Sheringham Shoal and Dudgeon Offshore Wind Farm Extension Projects

Draft Statement of Common Ground with National Highways (Revision C)

Revision C
Deadline 5
June 2023
Document Reference: 12.22

TITLE  
A47 EASTON  
DRAFT  
ACC47 ACCESS DESIGN  
(SHEET 1 OF 2)

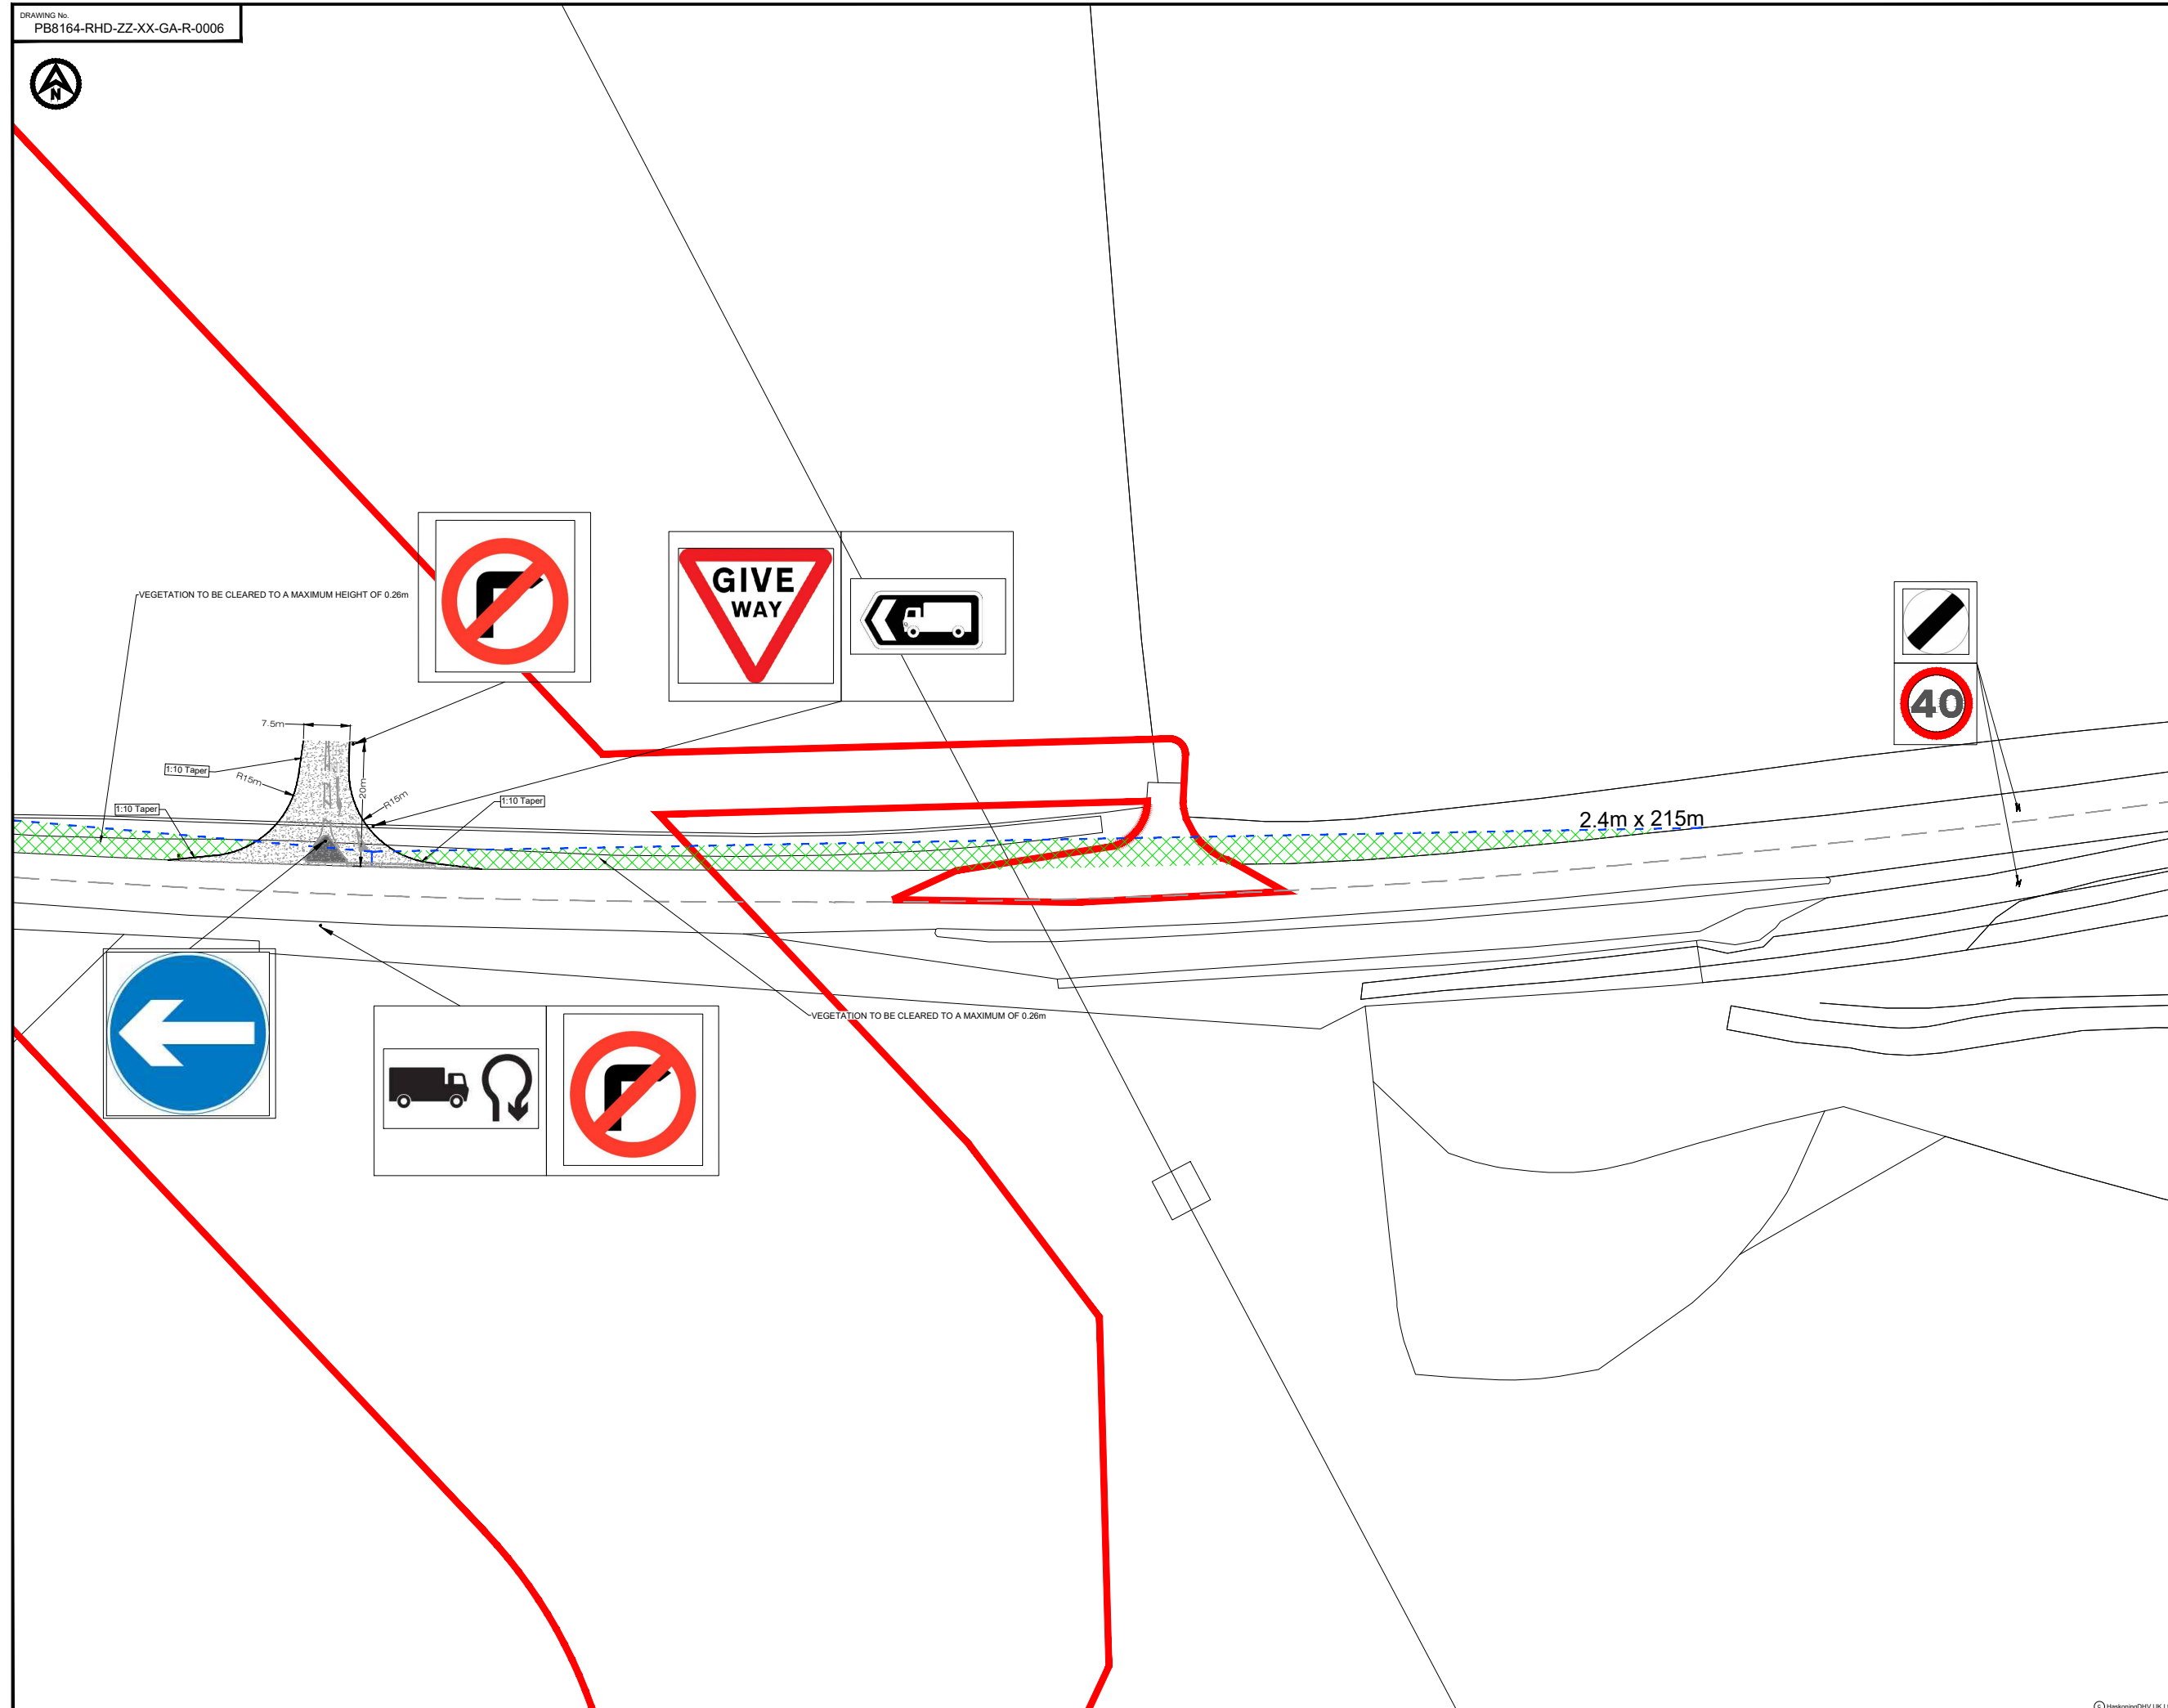
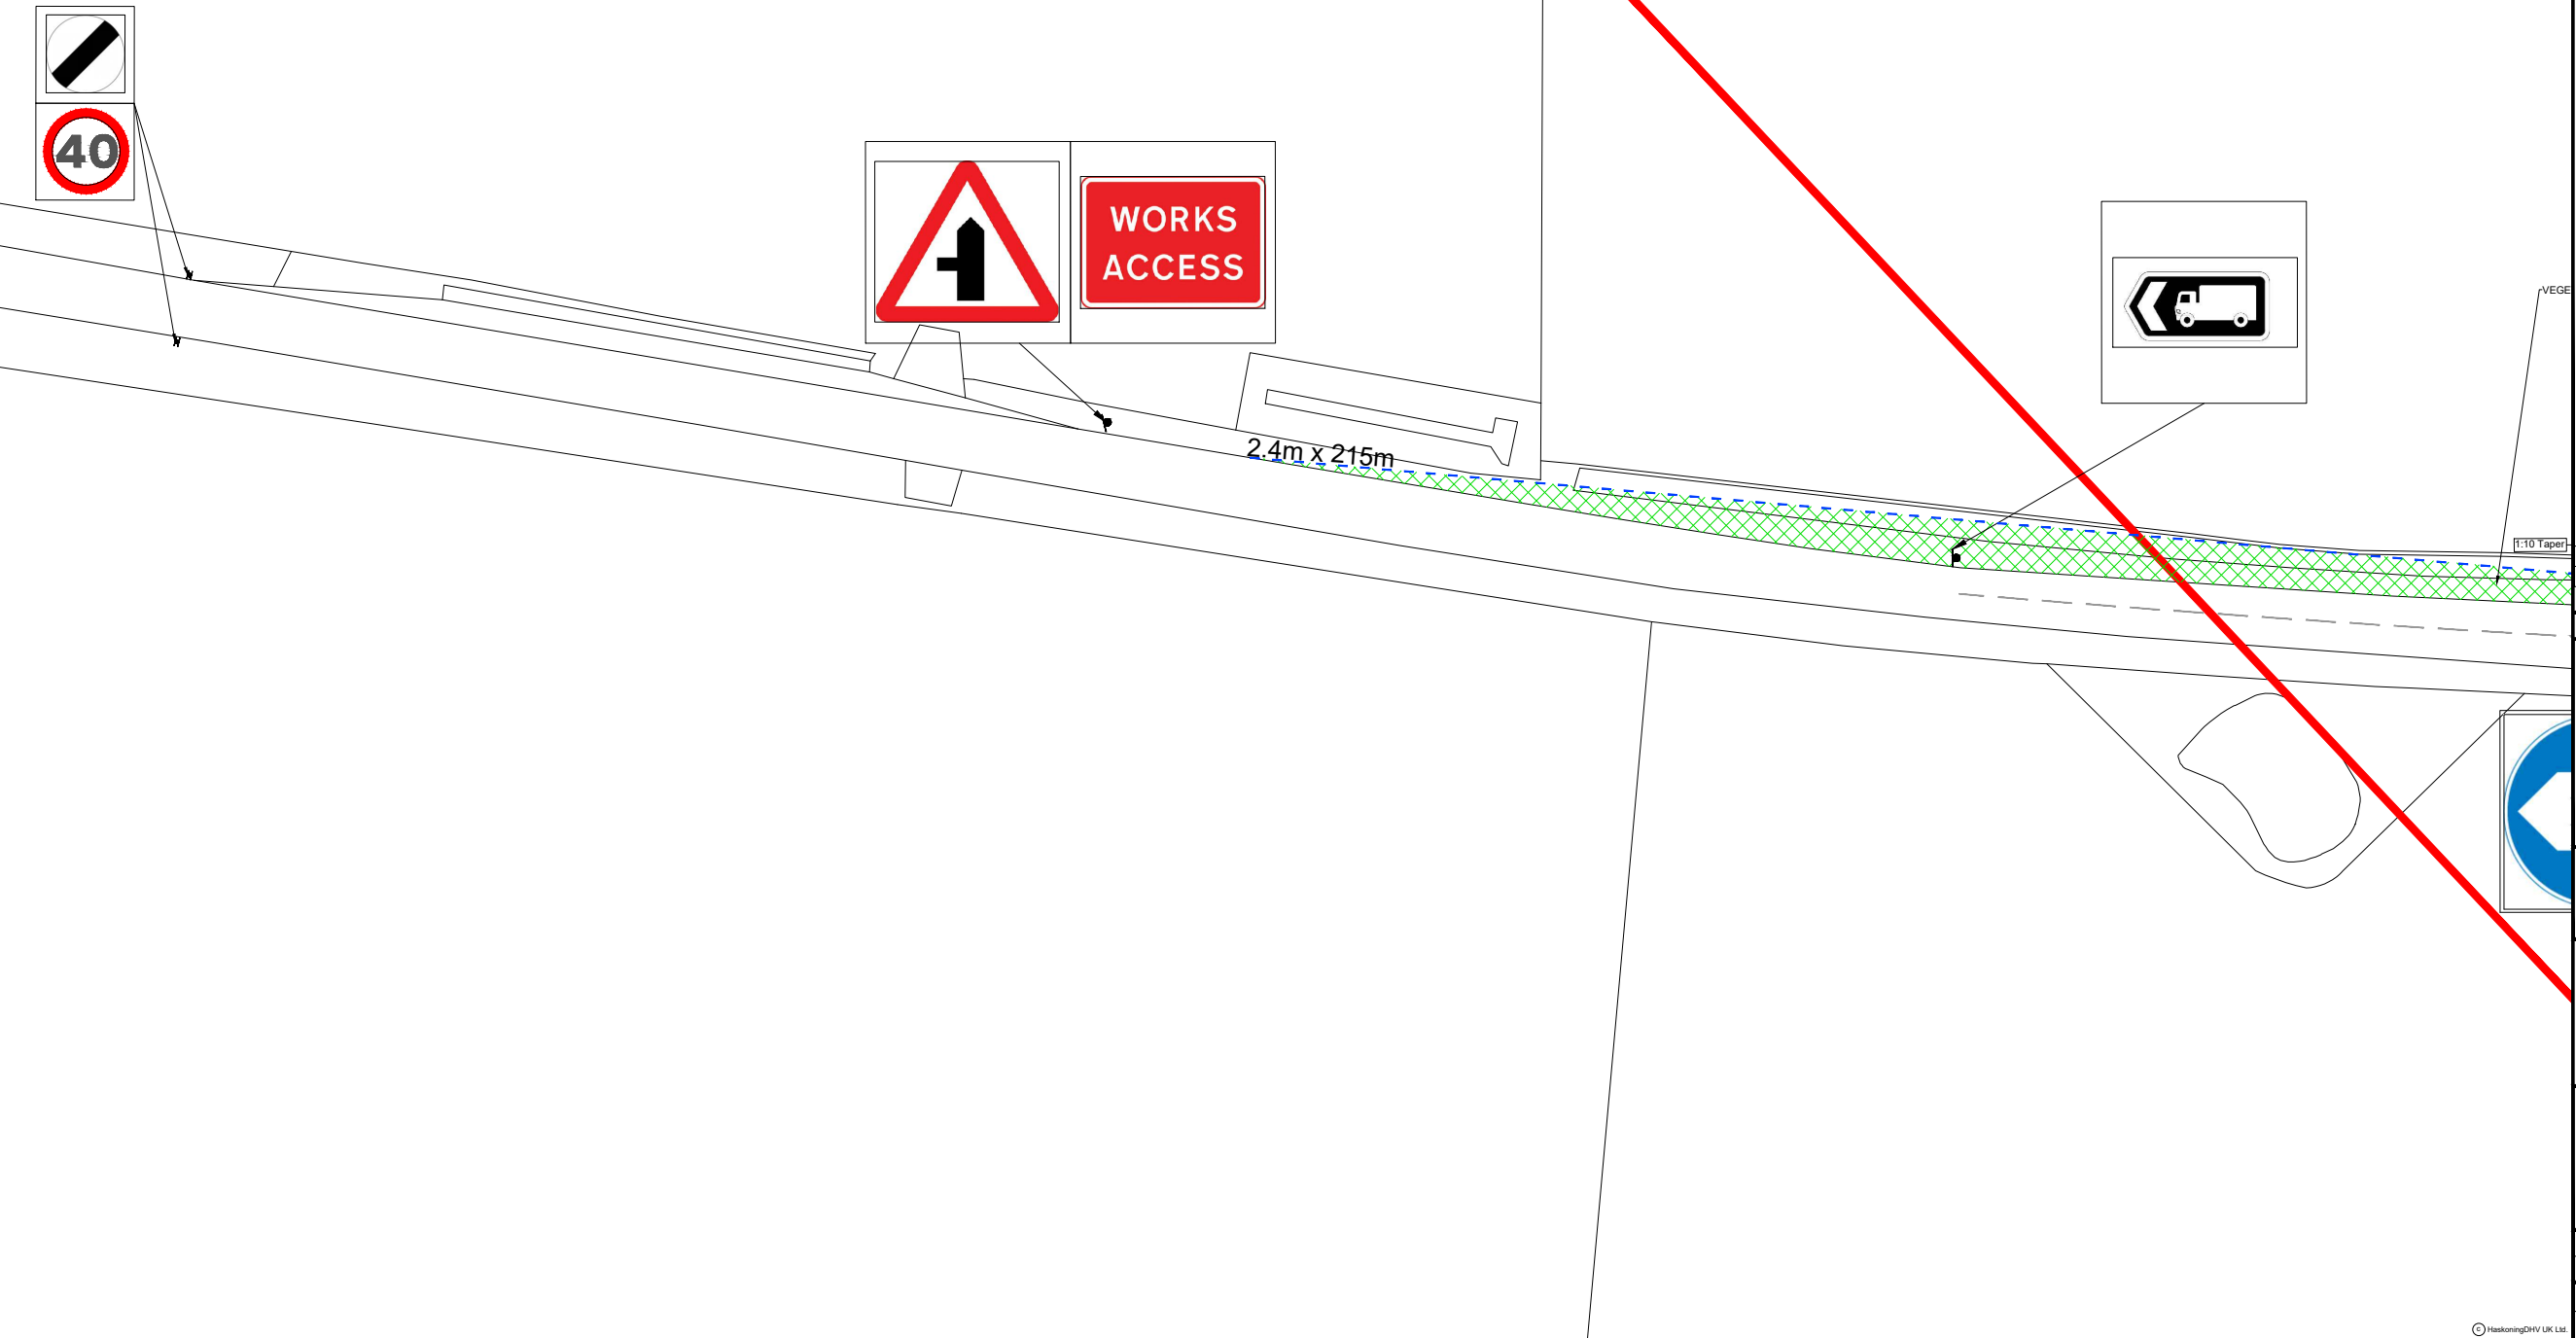
23	The outline design for an access off the A47 is appropriate, as presented in Annex 30 of the Transport Assessment [APP-268 and APP-269]	National Highways agree that the outline design for an access off the A47 (ACC47) is appropriate subject to Stage 1 and 2 Road Safety Audits being carried out post consent. Please note that this access is only usable until the A47 Tuddenham scheme starts construction, or if the A47 Scheme does not go ahead.	<i>Agreed</i>
EIA – Cumulative Impact Assessment (CIA) Conclusions

ID	The Applicant Position	National Highways Position	Position Summary
		mitigate likely significant impacts identified in the ES Chapter 24 Traffic and Transport [APP-110] for all other impacts.	
29	The access concept design for access ACC47 is appropriate and that detailed access designs can be developed and agreed with National Highways prior to the start of construction, secured under Requirement 16 of the draft DCO [AS-009].	National Highways agree that the access concept design for access ACC47 is appropriate, subject to Stage 1 and 2 Road Safety Audits to be carried out post consent, and that detailed designs can be developed and agreed with National Highways prior to the start of construction, secured under Requirement 16 of the draft DCO.	<i>Agreed</i>
30	The monitoring procedures set out in the OCTMP (Revision D) [document reference 9.16] are appropriate.	National Highways have requested further amendments to the OCTMP to include a monitoring group that is set up and chaired by the Applicant which will consider whether the CTMP is being carried out and working. The Applicant and National Highways have agreed at a meeting on the (06/06/2023) that the Monitoring Group will include a review of the outputs of the Monitoring Report and discuss any remedial measures. These amendments will be captured within Revision D of the OCTMP at Deadline 5. National Highways position on this matter is reserved pending review of Revision D of the OCTMP at Deadline 5.	<i>In Discussion</i>
